Our Case Number: ABP-318802-24

Re: Proposed development of a resource recovery centre (including waste-to-energy facility)
in Ringaskiddy, County Cork.

OBSERVATION ON SID APPLICATION - Case reference: PA04.318802, Ringaskiddy Co Cork

Proposed development of a resource recovery centre (including waste-to-energy facility)
by Indaver NV t/a Indaver Ireland

10.1 Baseline Noise Monitoring Locations

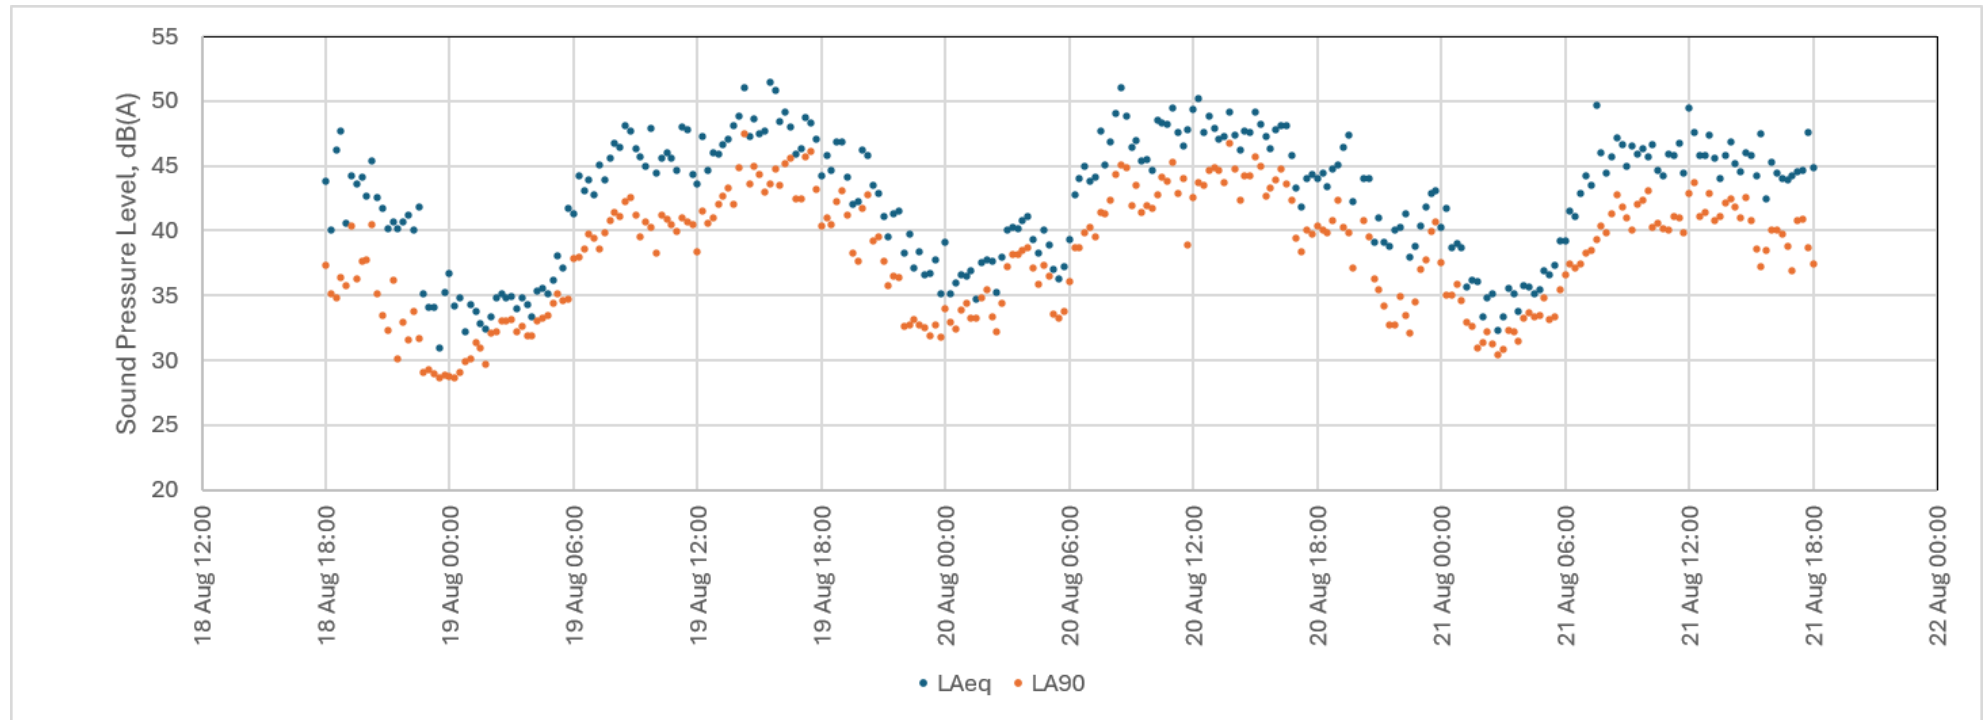
Insufficient Baseline Monitoring and Receptor Coverage: Limited to five clustered sites (N1-N4, <400m west/north), omitting eastern/coastal points; biases "not significant" findings, non-compliant with ISO 1996-2:2017 and stratified sampling precedents (e.g., Dublin Port EIS).
